Ref: H07/1428/01

Re: Proposed bungalow and garage at Station Road Gedney Hill

Amendment: Resiting of bungalow. Change to 'Full' application.
Dwg.No. 674PC2

Amendment: Amendments to garage - see letter & plans
Dwg no. 674PC2

DRAWING/FILE No 674PC2

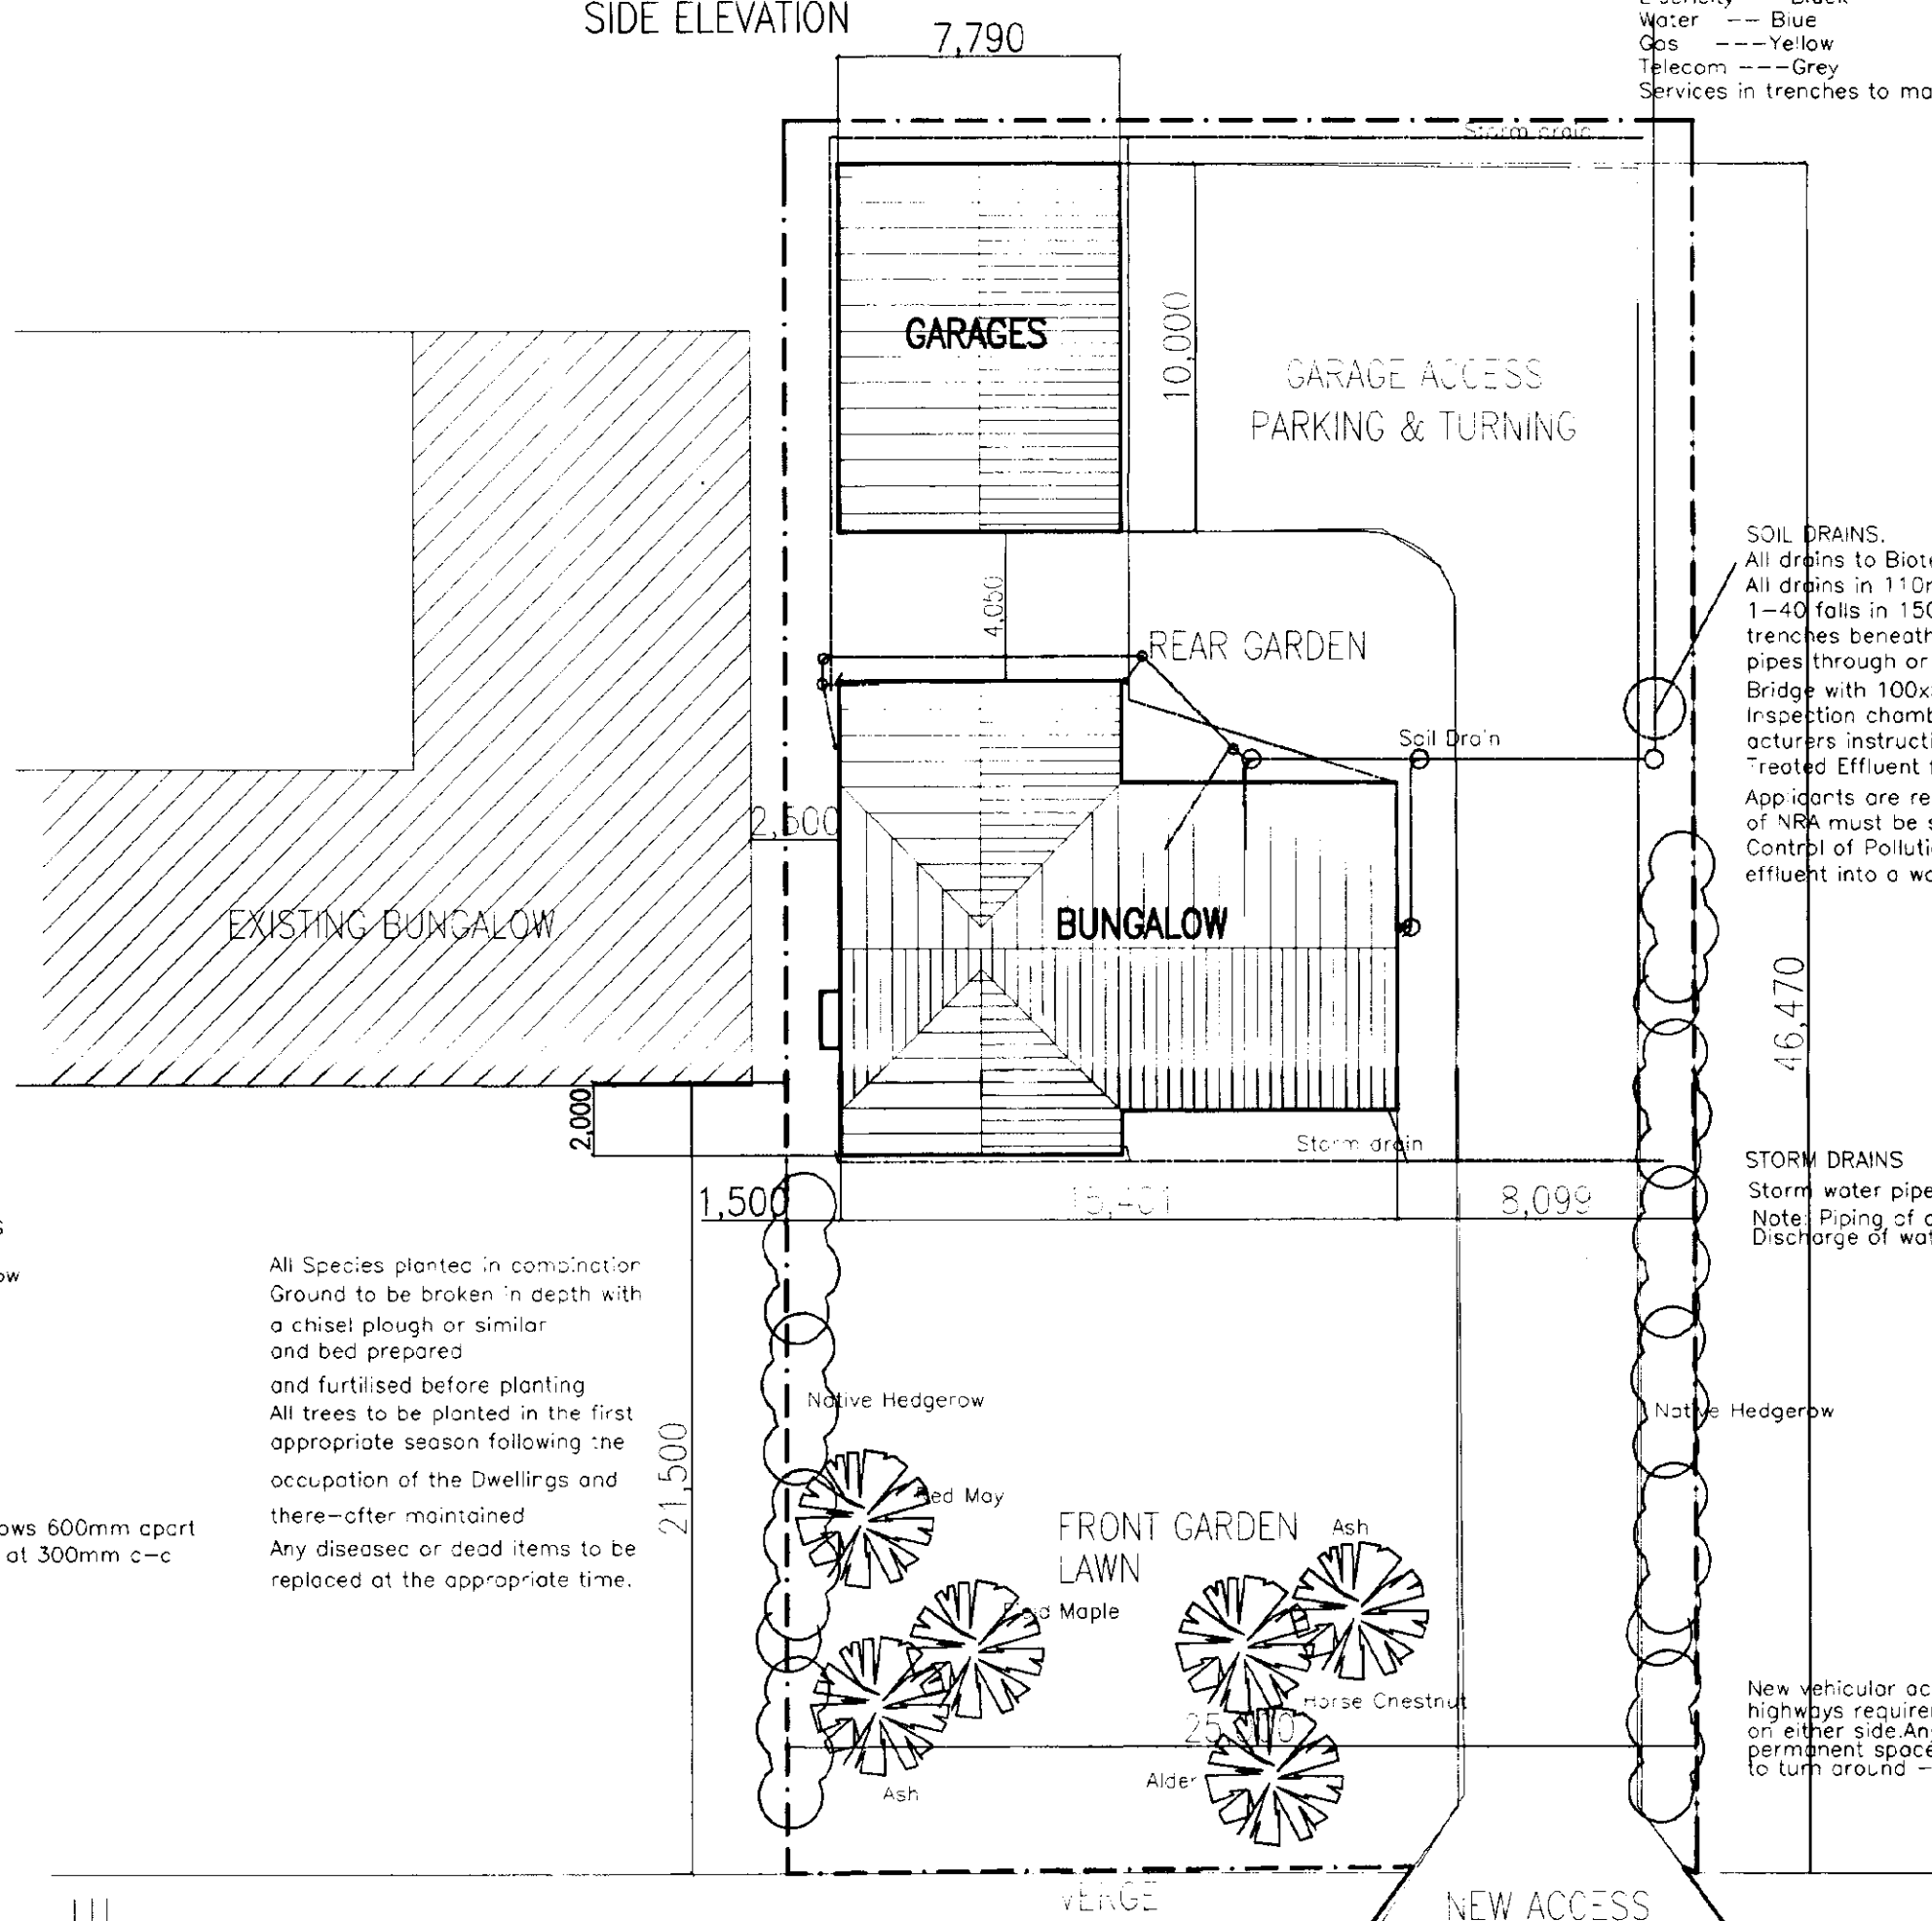
I enclose a revised block plan for the above scheme. Having discussed the matter with my client and checked on site, the adjacent bungalow is approximately 1 metre from the boundary, and therefore my client wishes to site the bungalow 1.5 metres from the boundary, which will give 2.5 metres between buildings.

GARAGE FRONT ELEVATION

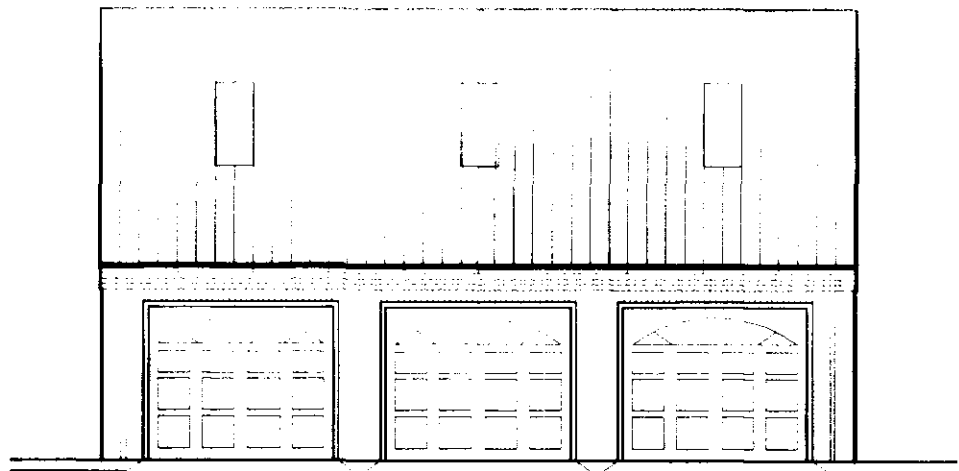
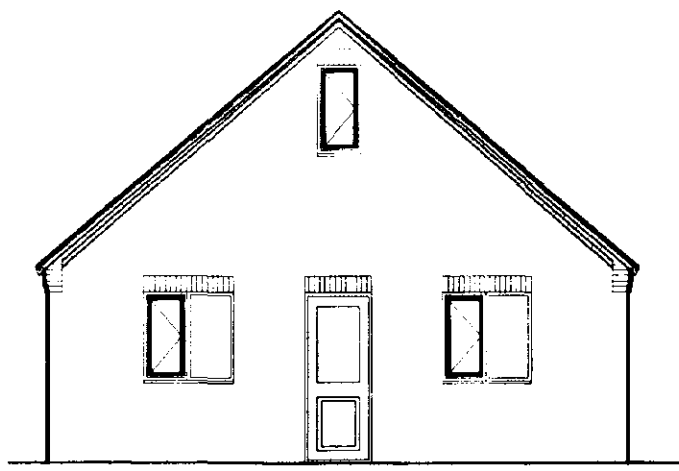
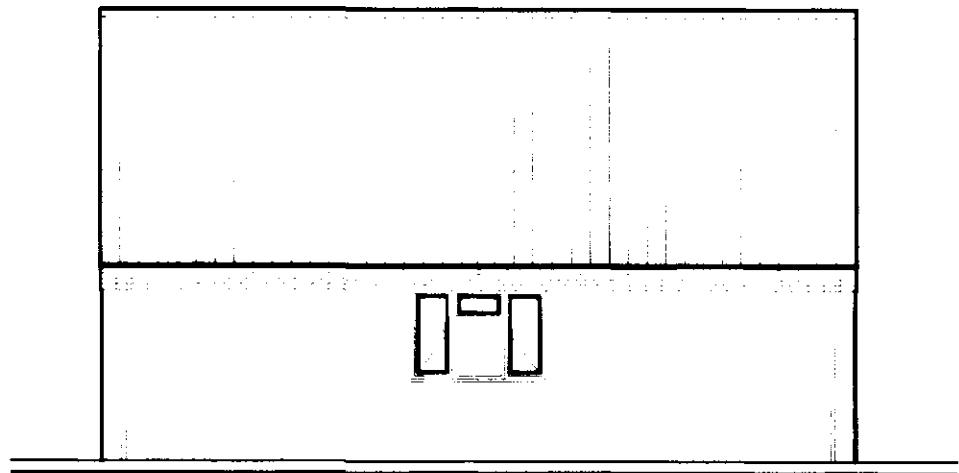
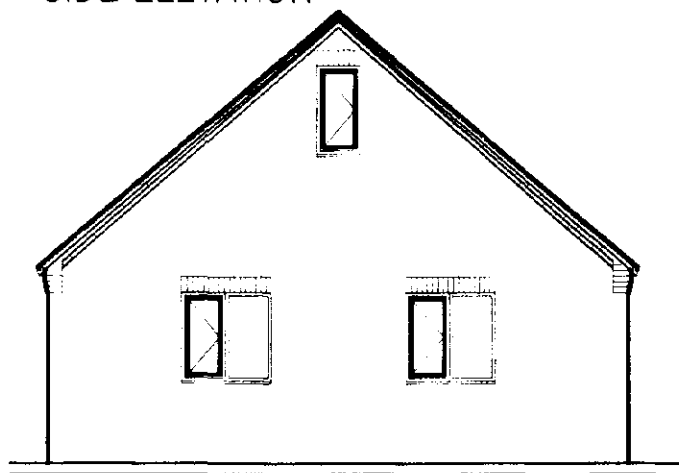
I have been asked by my client to submit an amended plan for the garage which shows a roof pitch increased from 30° to 40°, Velux windows and windows in the gables. This will enable him to use the roof for storage etc. Can this be accepted as an amendment to the approval.

The amended details submitted in respect of the above proposal have been received and I consider that the changes are too significant to be treated merely as a amendment. A fresh application will therefore be required (forms enclosed). This does not imply that permission will or will not be forthcoming for any such revised application.
